## City of Albuquerque Stormwater Construction Site Inspection Report

Project Name:		Alameda Crossing (f.k.a. Campo del Norte)					
Location:		ESC File No.		NPDES Id. No.			
Site Contact Name & Agency	Chris Montoya - Pulte		Phone: (o)				
	<a href="mailto:Christopher.Montoya@PulteGroup.com">Christopher.Montoya@PulteGroup.com</a>		Phone: (m)		505-277-7727		
Owner	Pulte Homes		Phone: (o)				
Owner's e-mail			Phone: (m)				
Inspection Date:	09/11/20	Start/End Time:	0945/1030hrs				
CoA Stormwater Inspector:		Timothy E. Sims					
Construction Phase:		home construction					
Type of Inspection:	Regular	Storm Event	Post Storm Event >0.25"	311/Complaint	x	Follow Up

CAMPO DEL NORTE
EROSION CONTROL PLAN

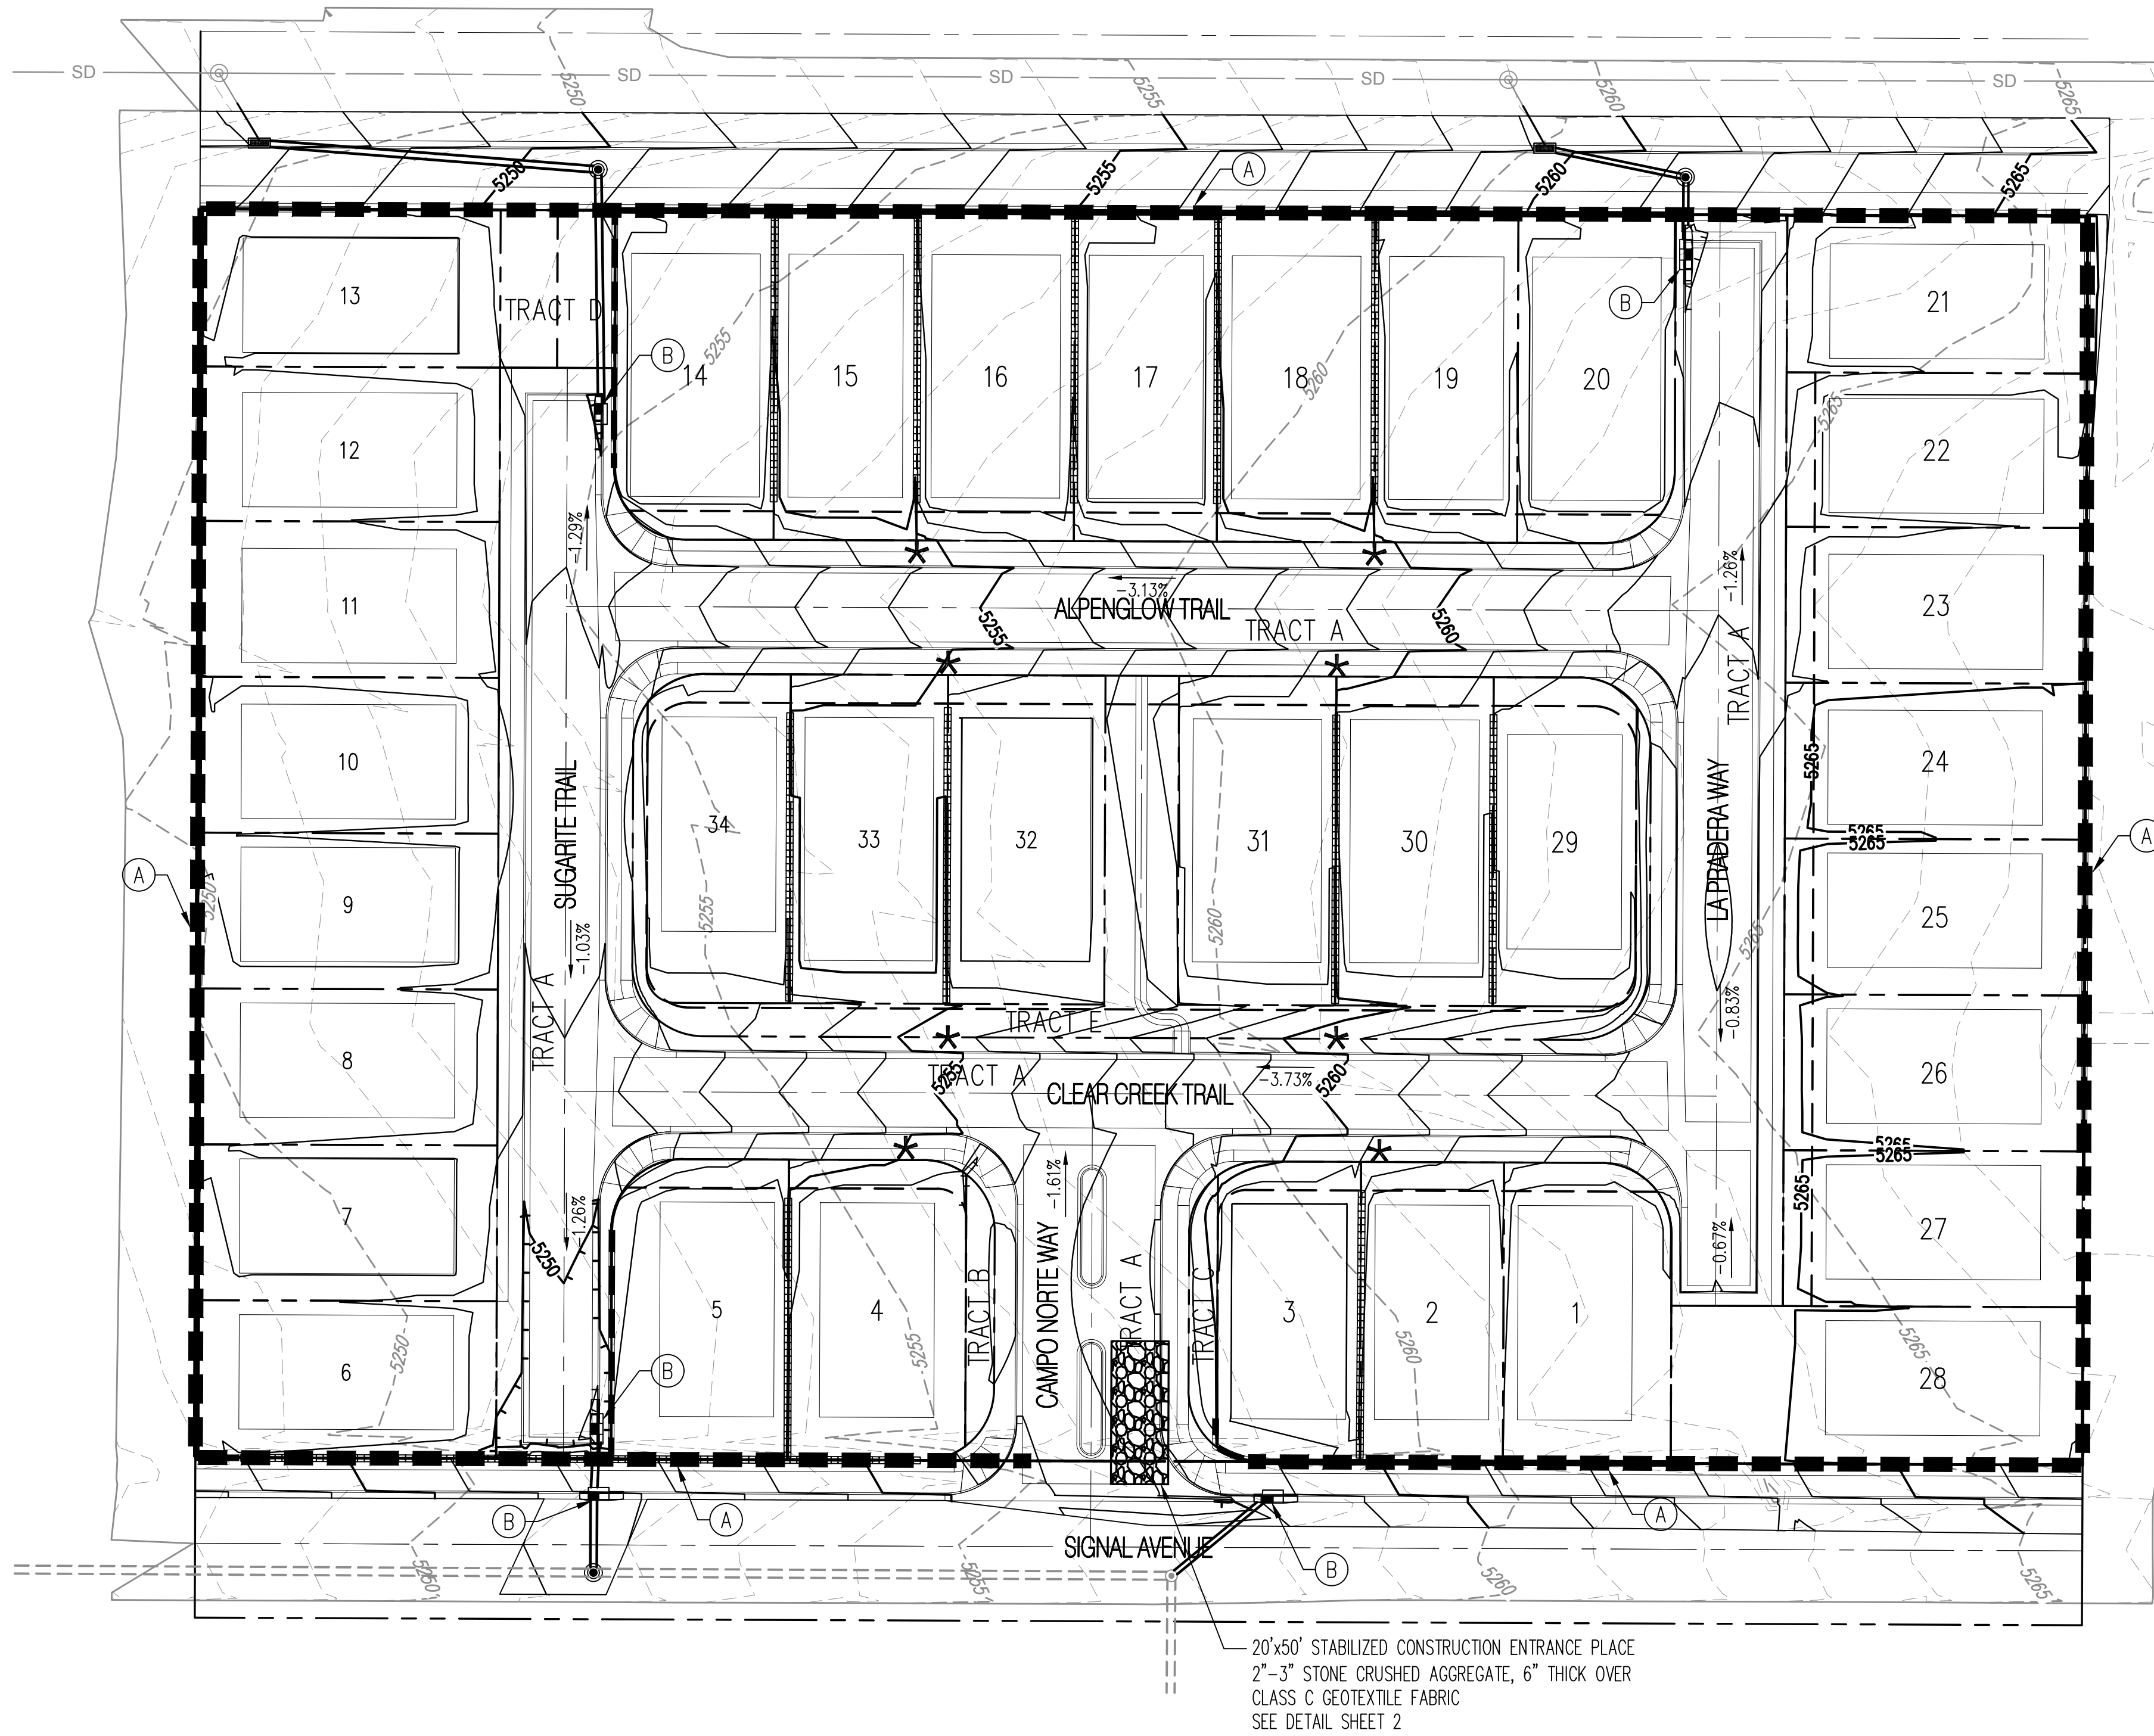
Item Number	Deficiency/ Corrective Action		
1	Sediment BMP or stabilization of soil north of property line and curb line of Alameda		
2.1	Discharge off site? (Y/N)	No	
4	Self Inspection Reports		Latest report Date:
